CITY OF ALBUQUERQUE

**Planning Department
Transportation Development Services Section**

Re: Certification Submittal for Final Building Certificate of Occupancy for
Richmond Street Studios, [K-16 / D66]
117 Richmond SE
Architect's Stamp Dated 12/13/06

Re: Certification Submittal for Final Building Certificate of Occupancy for
Richmond Street Studios, [K-16 / D66]
117 Richmond SE
Architect's Stamp Dated 11/15/06

a.1

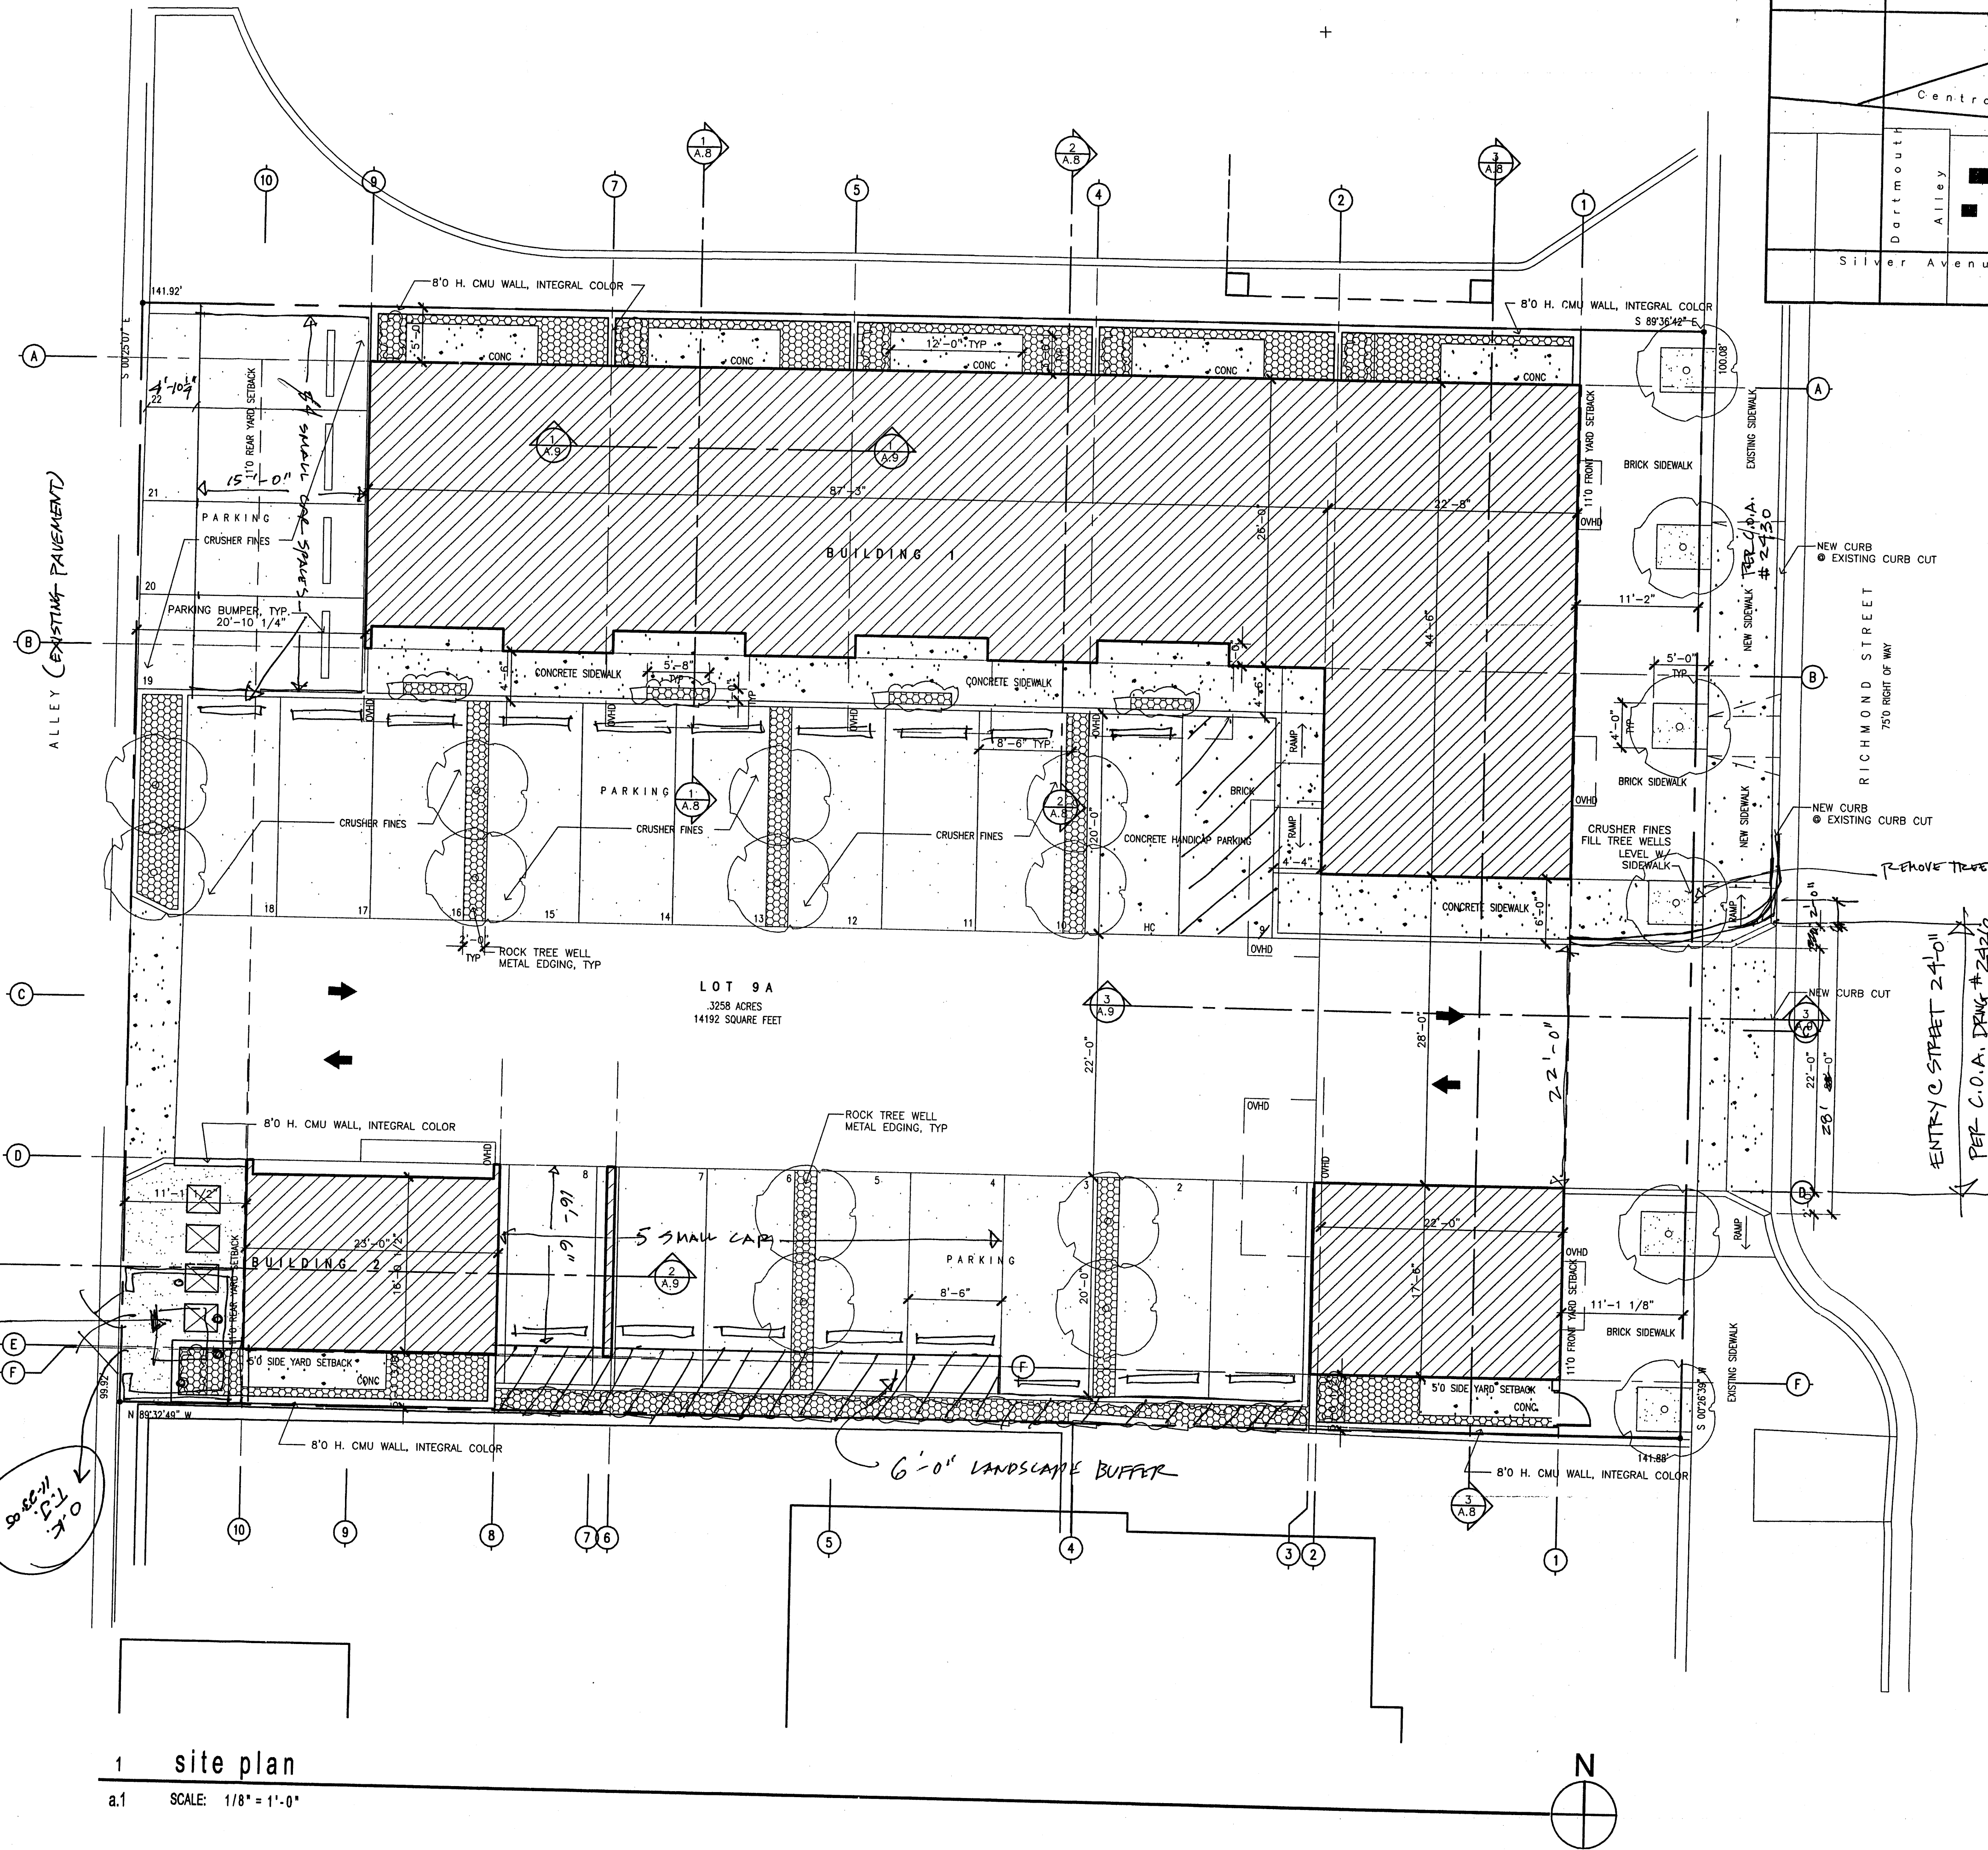
The TCL / Letter of Certification submitted on November 15, 2006 is not sufficient for acceptance by this office for final Certificate of Occupancy (C.O.). The Letter of Certification needs to have the following phrase as part of your wording, 'Substantial Compliance'. The entrance to the studio has need been constructed per the approved site plan. The drivepad needs to provide an ADA access route across the entrance which is not the case in accordance to field inspection.

I am resubmitting this Traffic Circulation Certification for Final Certificate of Occupancy for our project the Richmond Street Studios at 117 Richmond, SE. We have successfully addressed issues related to an ADA access route across the entrance drivepad per your field inspection instructions stated in your letter of November 16, 2006.
